Reference no. 2025/CL/90593/E

Site Address	Popeley Farm, Muffit Lane, Gomersal, Cleckheaton, BD19 4QS
---------------------	---

Description	Prior notification for change of use of agricultural buildings to one dwelling
--------------------	---

DECISION - REFUSED

client:	Knabbs Ash Barn Ltd
project:	Class Q Planning Application
location:	Popely Farm, Muffit Lane, Gomersal BD19 4QS
drawing title:	Unit A (B2) Floor Plan As Proposed
date:	31/07/23 drawn: jszn scale @ A3: 1:100 job no: 23.111
drawing no:	1107 revision: A

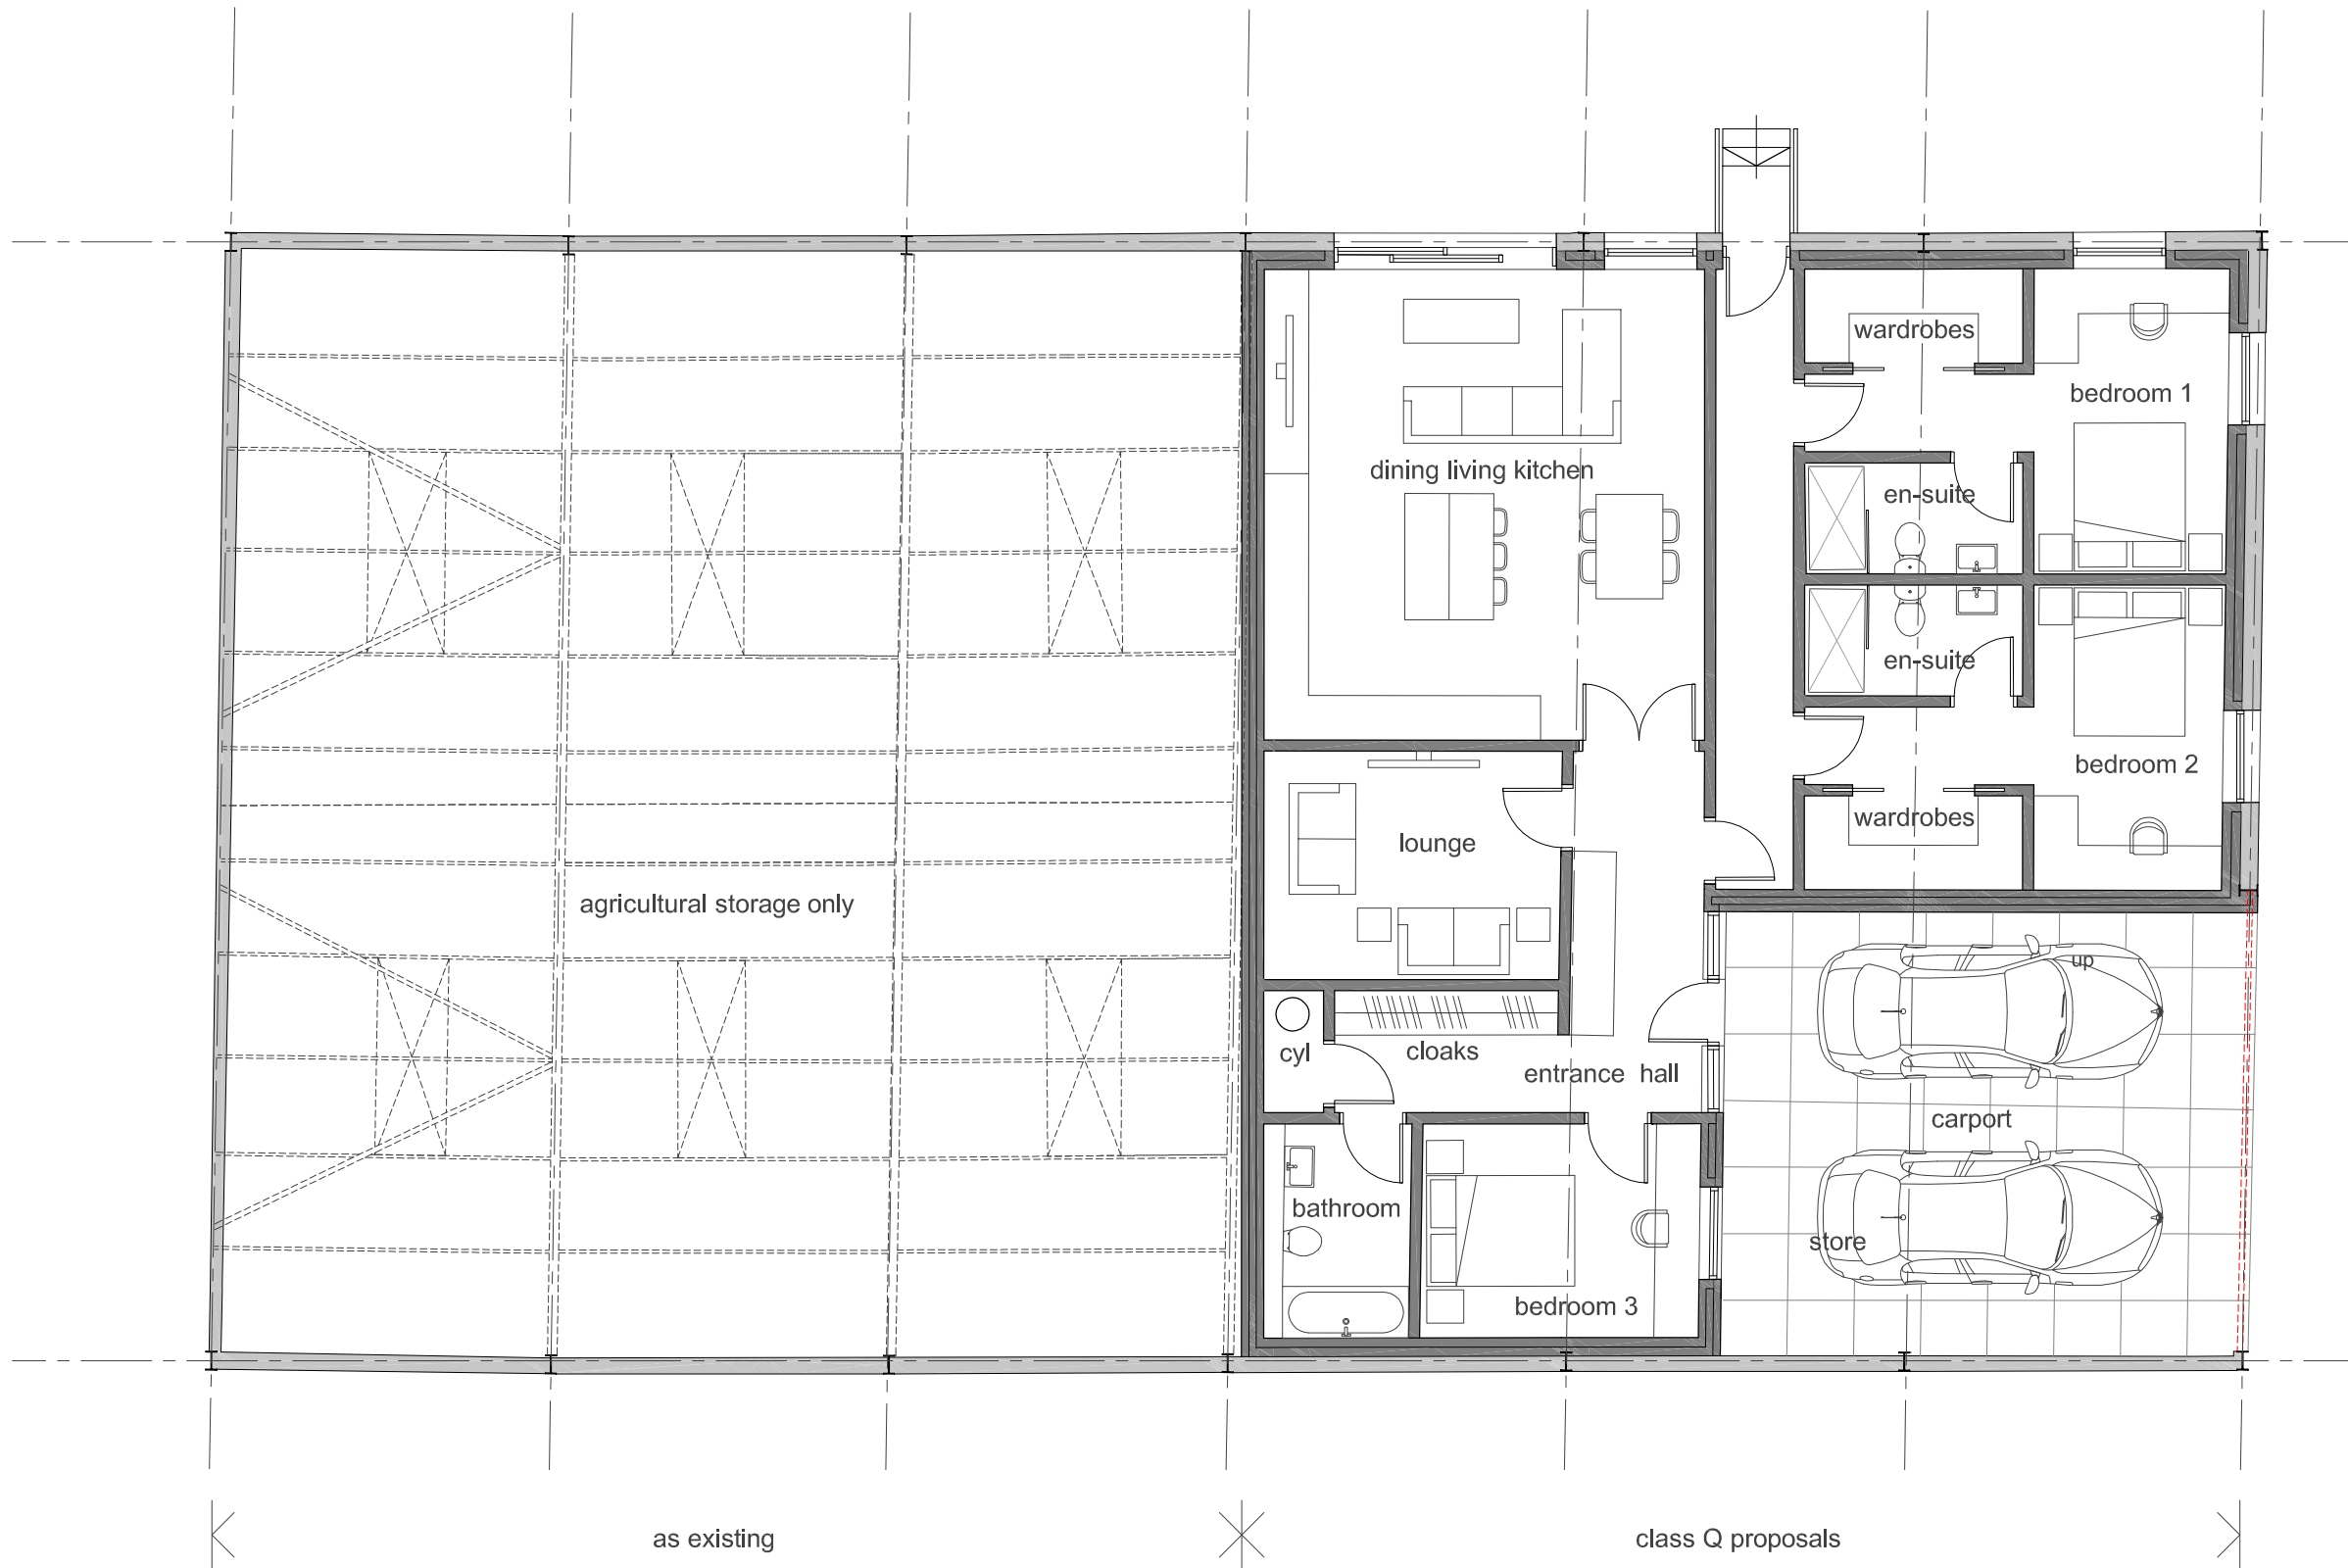
The proposed floor plans demonstrate that property would have three double bed spaces and would have an internal floor space of 150m² (excluding the carport). Furthermore, each of the habitable rooms would benefit from a sufficient amount of natural light and off road parking would also be provided on site. Furthermore, private outdoor amenity space is proposed to the north-west. For these reasons, it is considered that the proposal would provide an acceptable standard of living for future occupants.

client:	Knabbs Ash Barn Ltd
project:	Class Q Planning Application
location:	Popely Farm, Muffit Lane, Gomersal BD19 4QS
drawing title:	Unit A (B2) North & West Facing Elevations
date:	31/07/23 drawn: jszn scale @ A3: 1:100 job no: 23.111
drawing no:	1109 revision: B

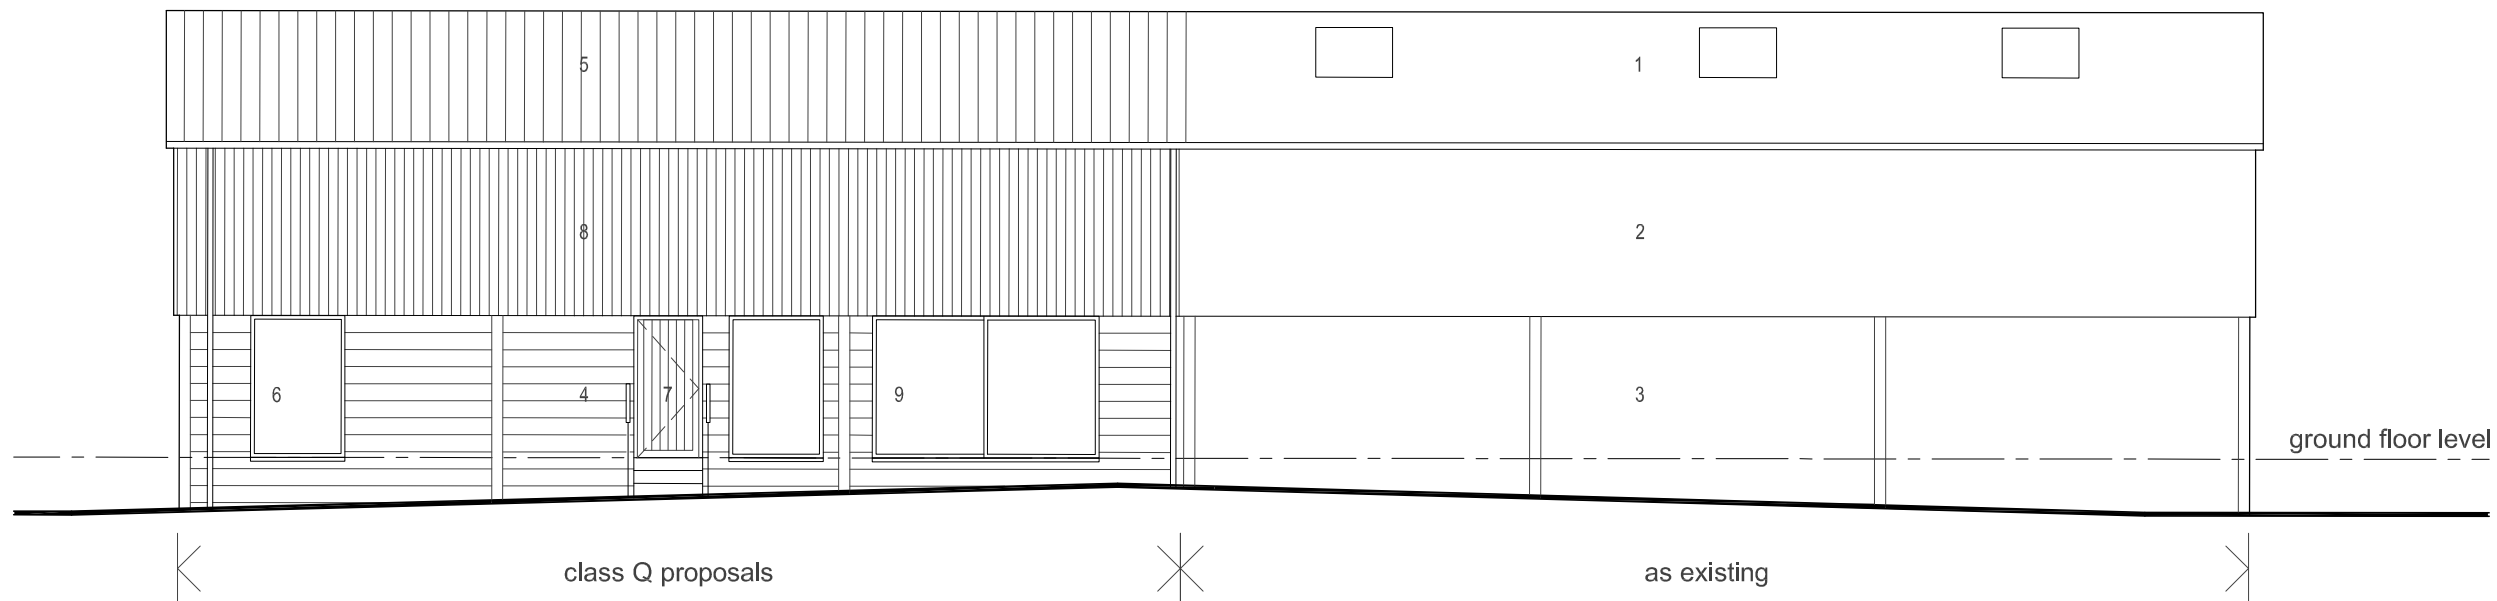
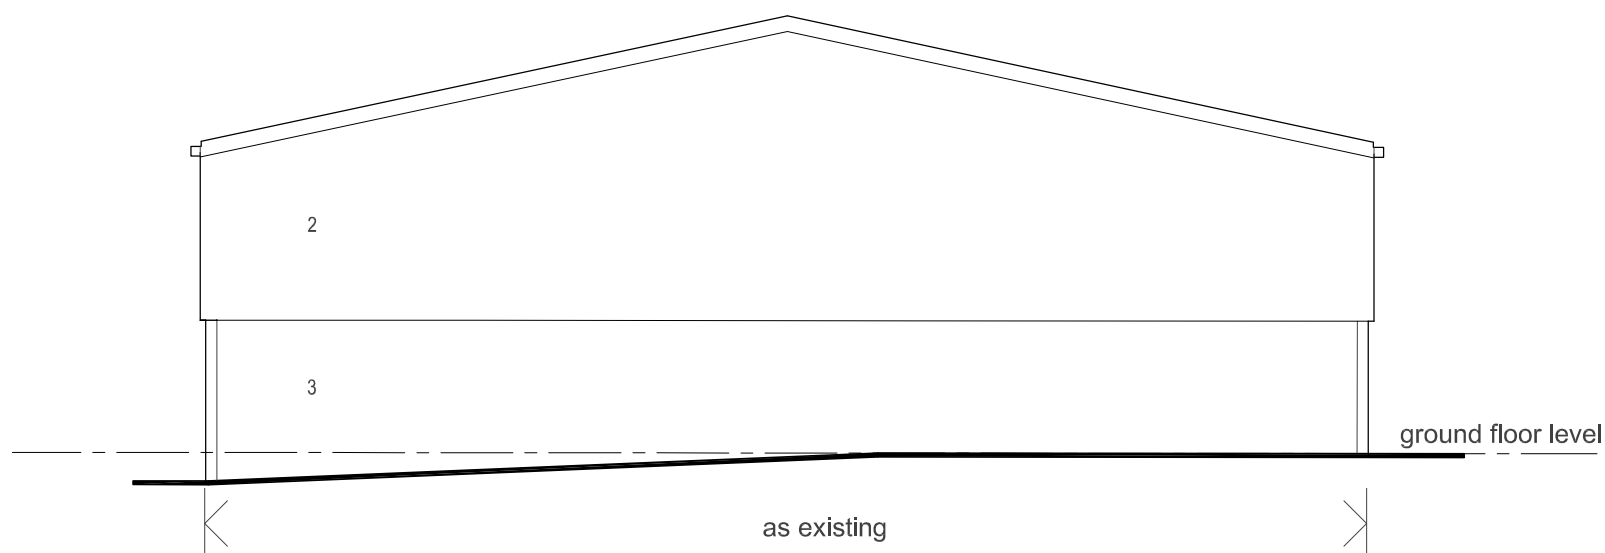
The submitted plans confirm that all the existing external walling and roofing will need to be removed as part of the proposal. The submitted plans confirm that the dwelling would be faced in new vertical timber cladding to the upper walls and concrete blockwork with dark grey paint finish on the lower sections. Furthermore, the roof would be finished in new profiled sheets. It is therefore considered, the building as it currently stands, would not be capable to function as a converted dwelling without the significant degree of proposed building works which are tantamount to a new build as set out in *Hibbitt*. In this case, the proposed works would be considered so extensive as to comprise

rebuilding and therefore cannot be considered within the definition of “conversion.”

The design of the dwelling would be somewhat determined by the existing building, the form of which is to be mostly retained. The submitted plans confirm that the dwelling would be faced in new vertical timber cladding to the upper walls and concrete blockwork with dark grey paint finish on the lower sections. Furthermore, the roof would be finished in new profiled sheets. Although this material palette is not typical for the site and wider area, it is considered that the appearance of the proposed dwelling would be sympathetic to the original building and the surrounding rural character.

1. The building operations described in the application are considered to go beyond works that could reasonably be described as development to convert an existing agricultural building and as thus considered as a matter of fact and degree to constitute a re-build and therefore cannot benefit from a general planning permission by virtue of Article 3(1) and Class Q, Part 3 of Schedule 2 of the Town and Country Planning (General Permitted Development) (England) Order 2015 (as amended).
